# ENG-SF22025-R1-CDs.pdf Markup Summary

PCD File # 22-025

GRADING AND EROSION CONTROL PLANS

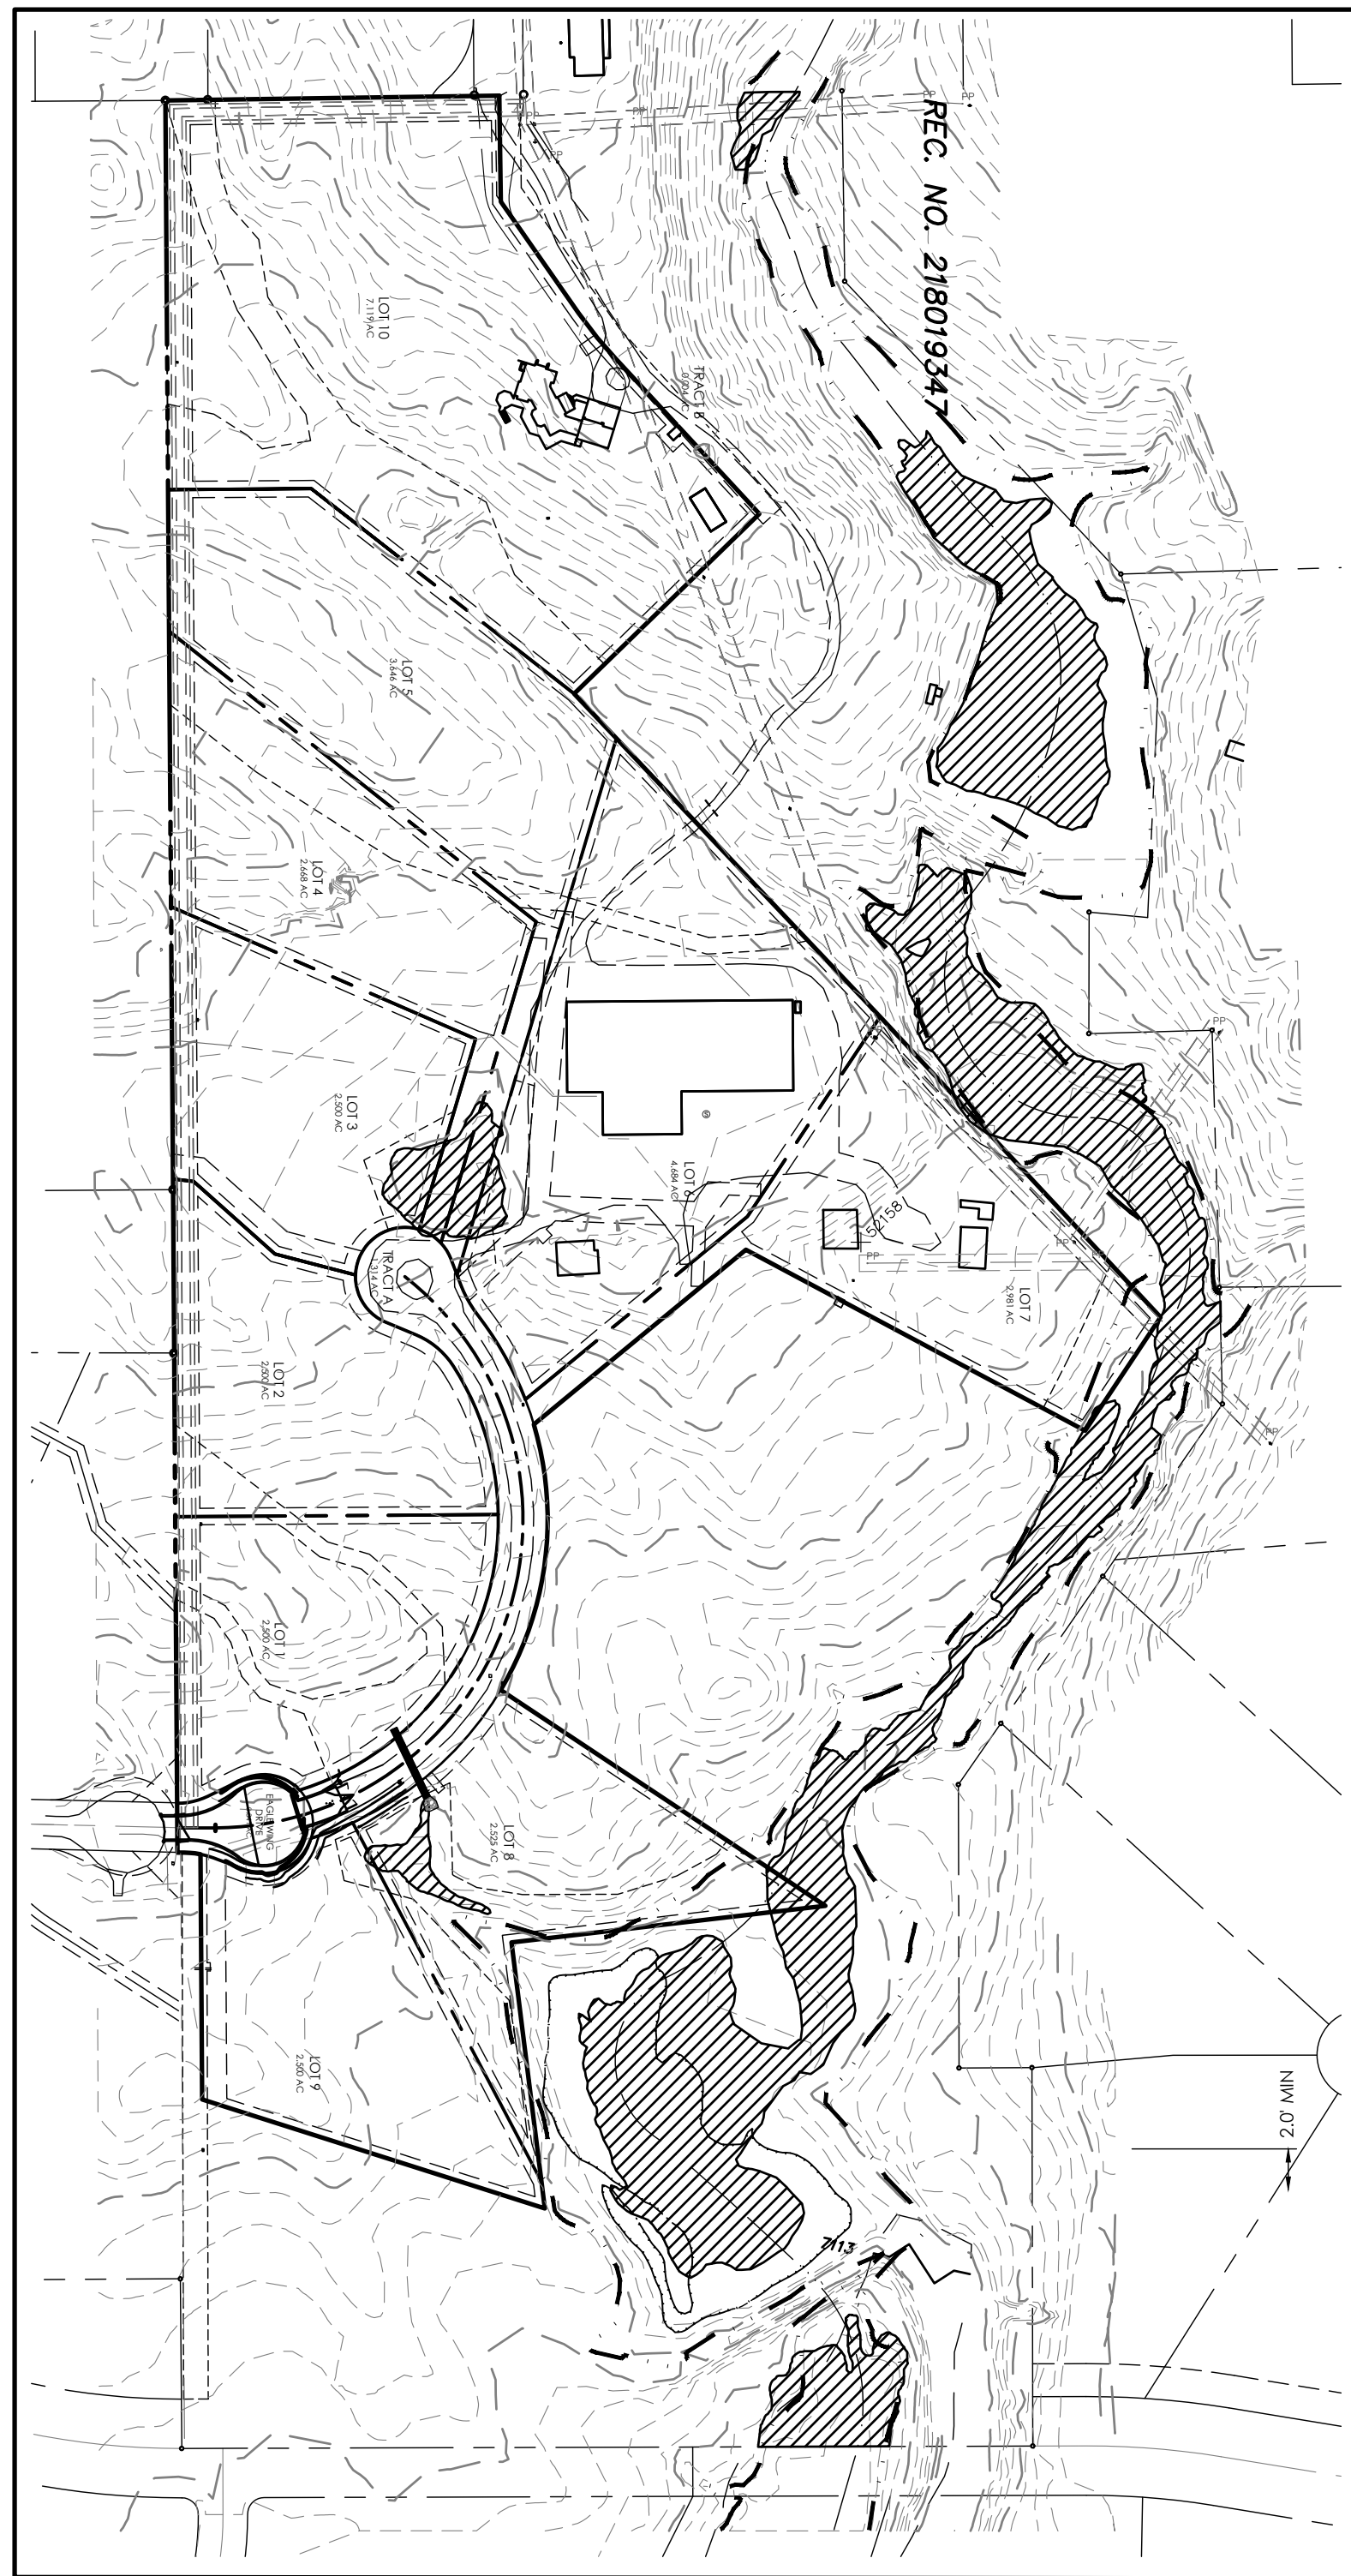
These GEC plan standard notes are not needed on the Construction Drawings. The are listed on the GEC plan. Can remove
